PLANNING CONSULTATION RESPONSE

Application No	2026/0431
Proposal	Prior Approval for electronic communications network. 20m High, Orion Slimline Streetworks Monopole hosting 6 no. antennas, 3 no. ERS, equipment housing and ancillary development.
Address	Northeast of Southgate, Shafton, Barnsley S72 8QG
Date of Consultation Reply	10 th July 2026
Consultee	Highways DC

[2nd response]

Drawing Title	PROPOSED SITE PLAN
Purpose of Issue	PLANNING
Drawing Number	201
Surveyed By	SSB
Original Sheet Size	A3
Drawn	GJ
Date	18.02.26
Checked	PM
Date	18.02.26
Pack Issue	A
Issue	B

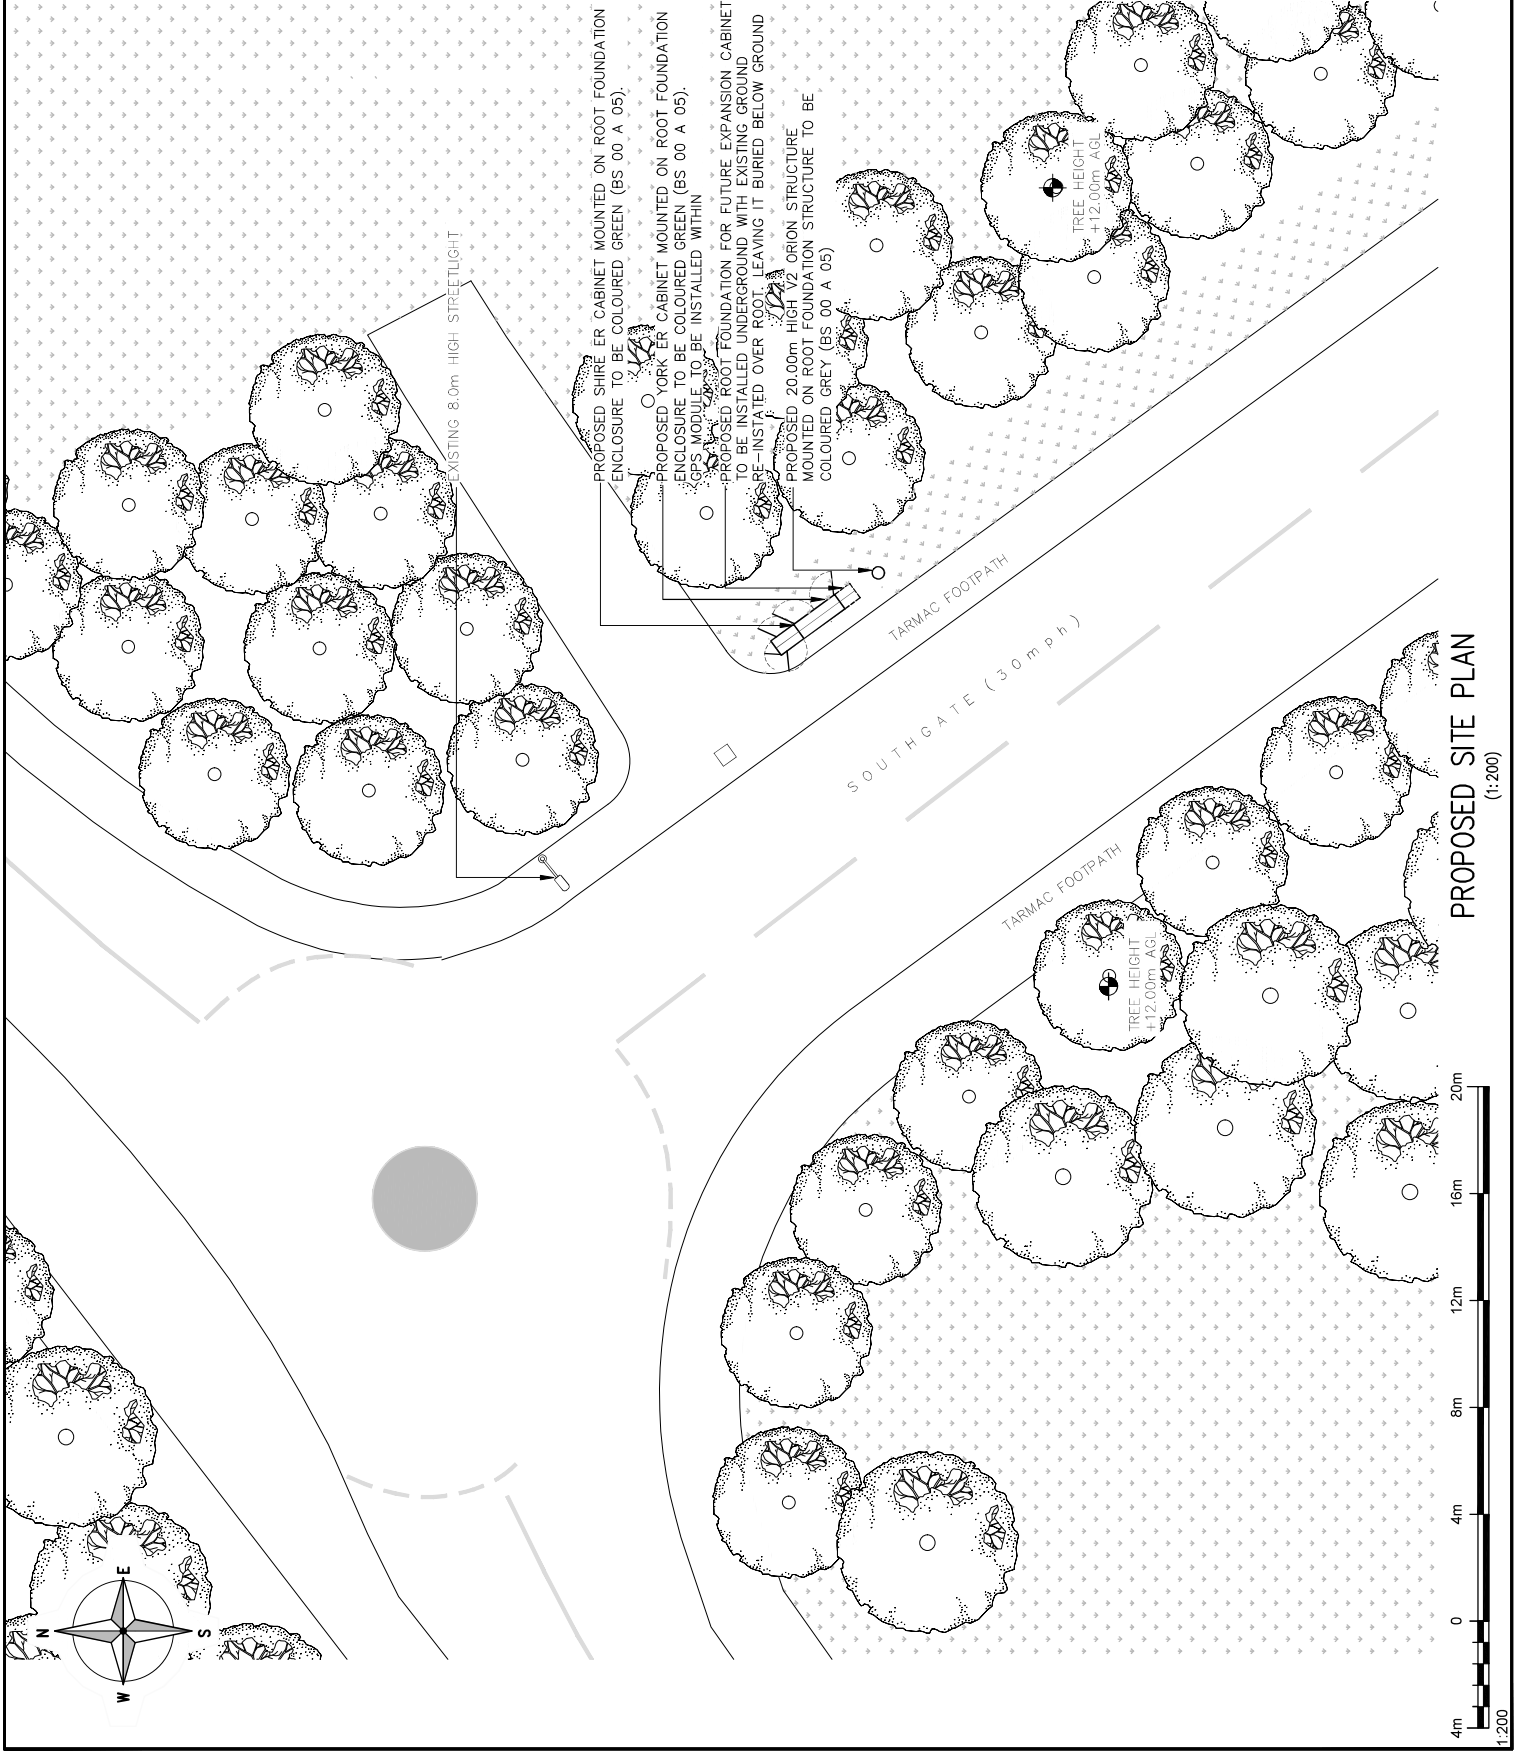
The amended plans show that the cabinet has been relocated to the south-east of the Monopole mast; the proposed communications equipment is now positioned a sufficient distance from the adjacent field access to allow farm vehicles to access/egress the field unimpeded.

The equipment does not interfere with any vehicular sight lines/visibility, nor does it constitute an undue distraction to road users, as such, it is considered that the proposals do not adversely impact upon the highway; there are no objections from a highways point of view.
